Subject: FW: Planning Consultation on: BR/39/19/PL

BR/39/19/PL - Application for Variation of Conditions following the grant of Planning Permission BR/240/16/PL relating to Condition 2 & Planning Permission BR/331/17/PL relating to condition 1 - approved plans

title: Ground Floor

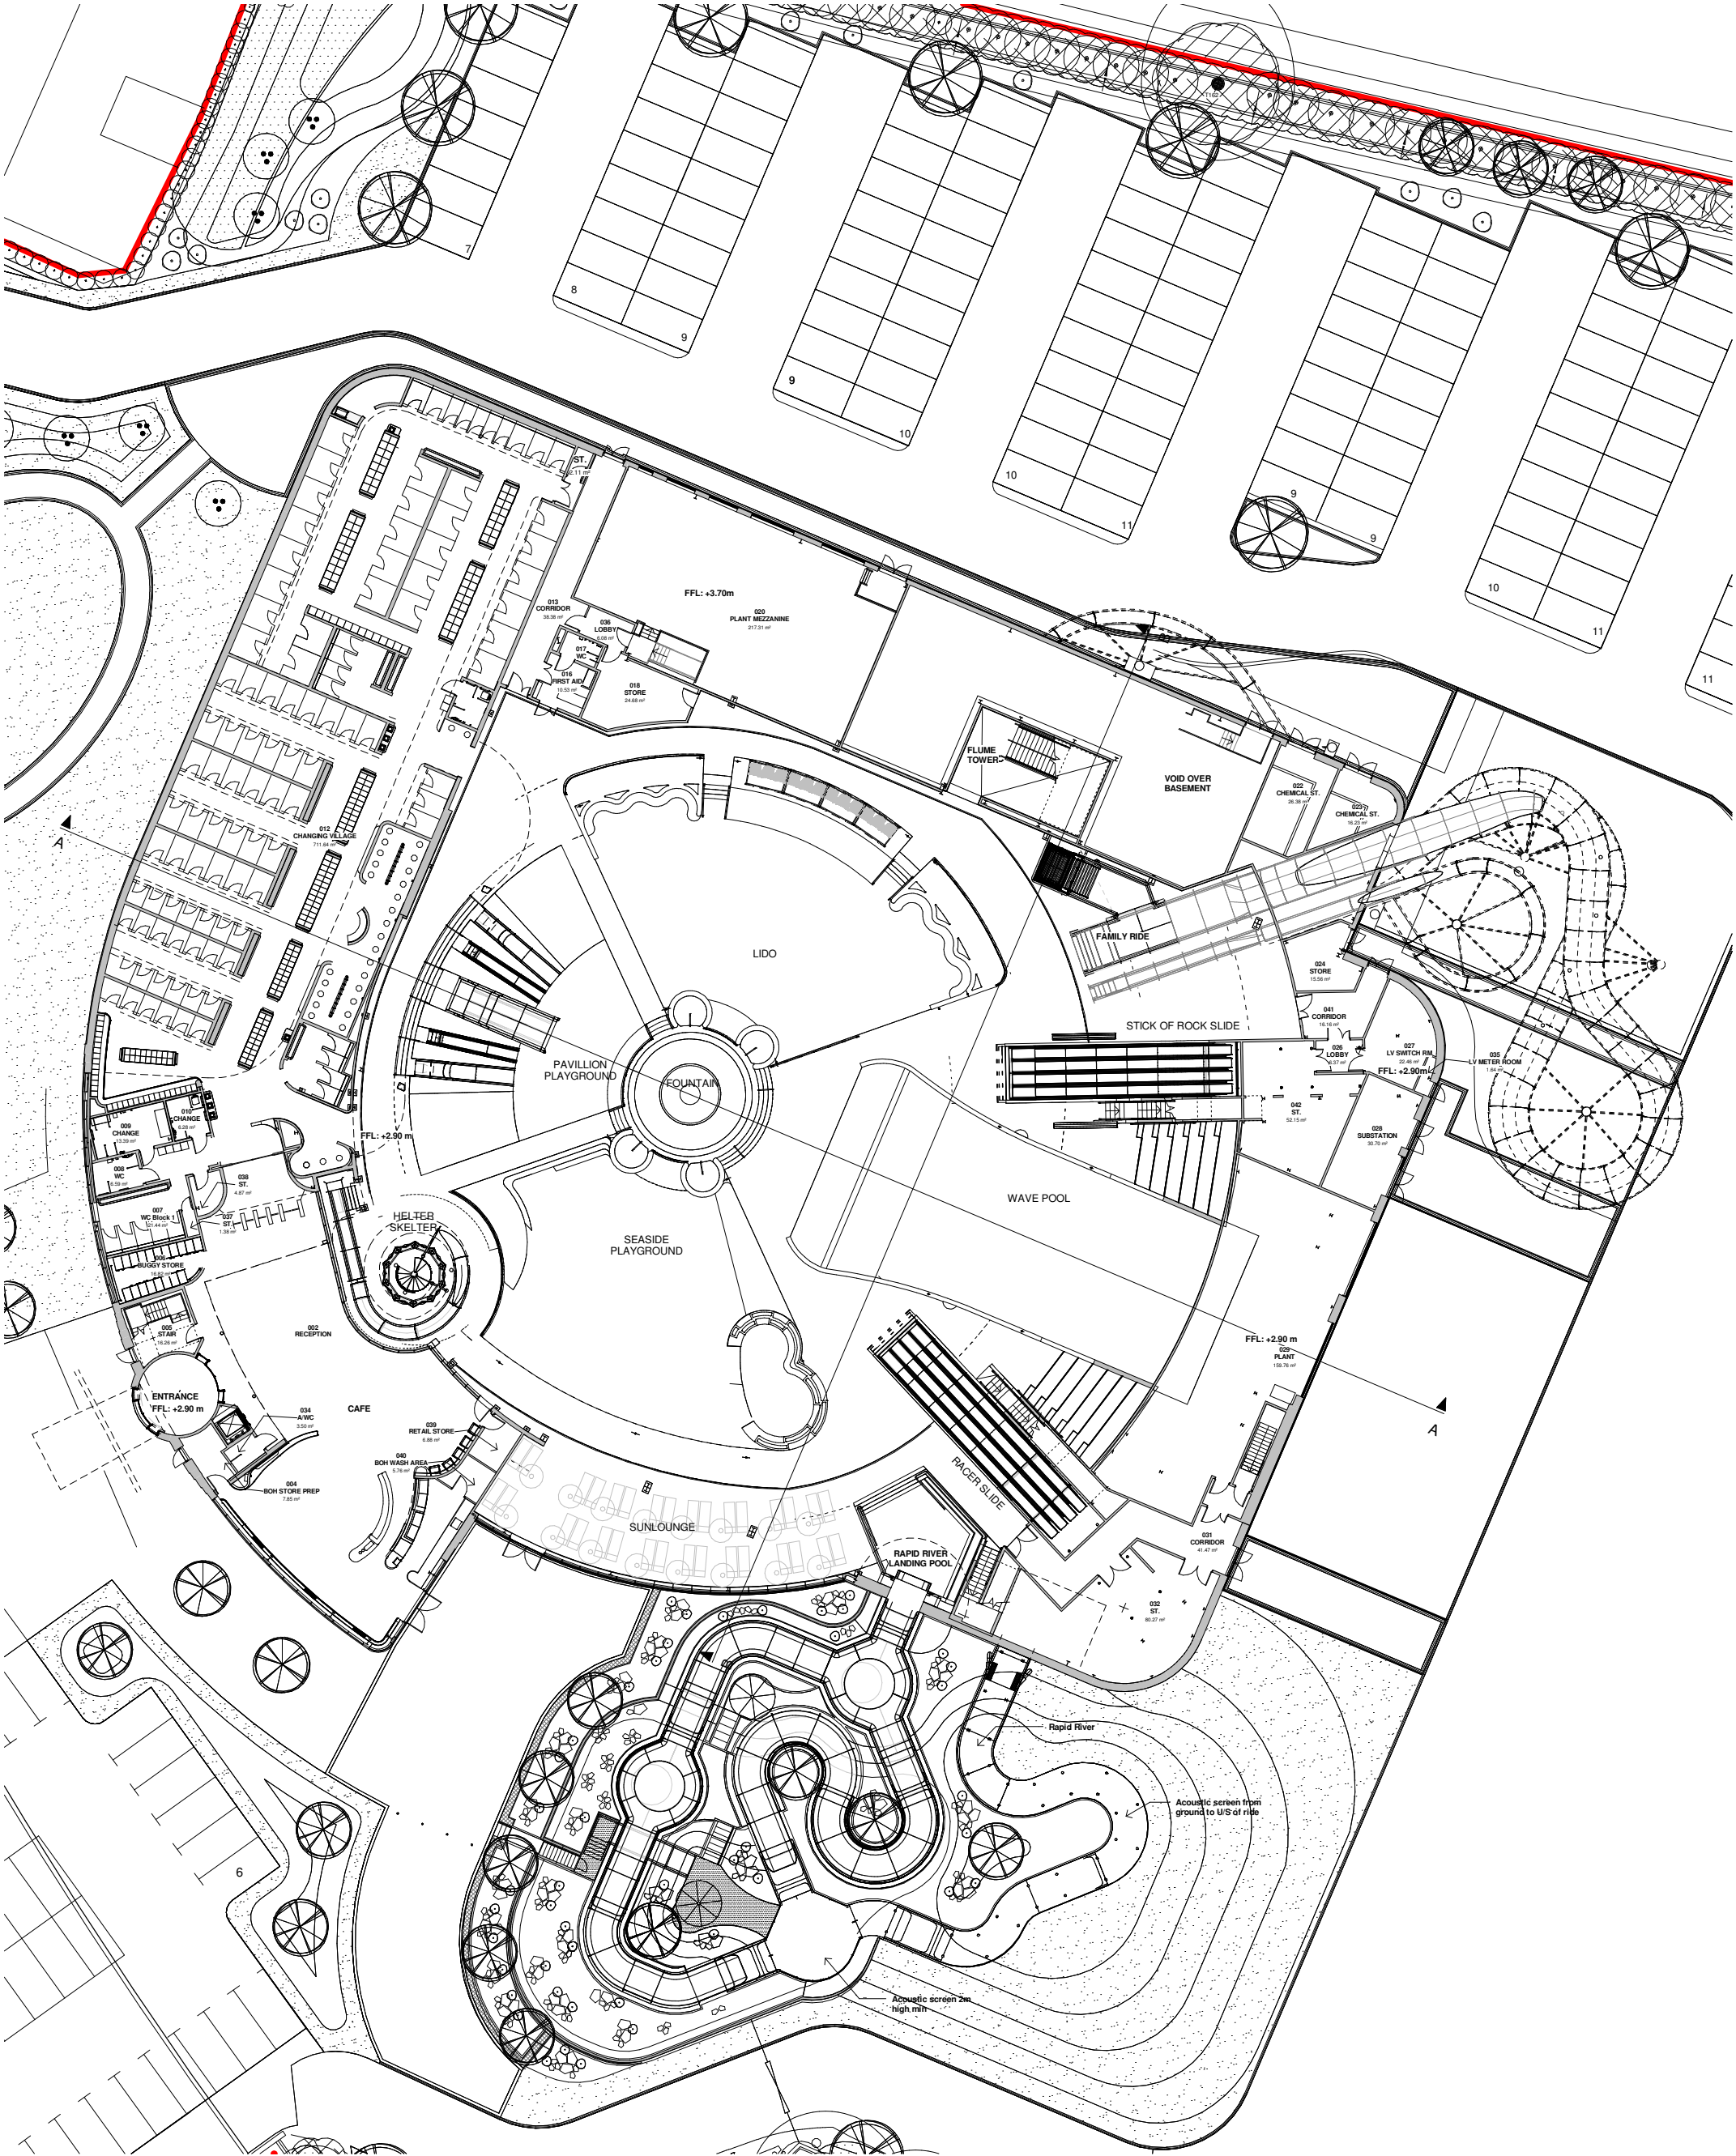
Please see comment below from Environmental Health. Can you advise re whether the amendments to the flume height and the rapid river design will have any adverse impact on the acoustic environment.

I note from the covering letter submitted with the application that it includes amendments to reduce the height of the flume, adjustments to the design of the rapid river and addition of louvres. They have stated that the louvres will have no impact on the acoustic performance of the building. However, I would request that the applicants also ask their acoustic consultant to confirm that the amendments to the flume height and the rapid river design will have no adverse impact on the acoustic environment. If this is the case then environmental health would have no objection to the amendments.
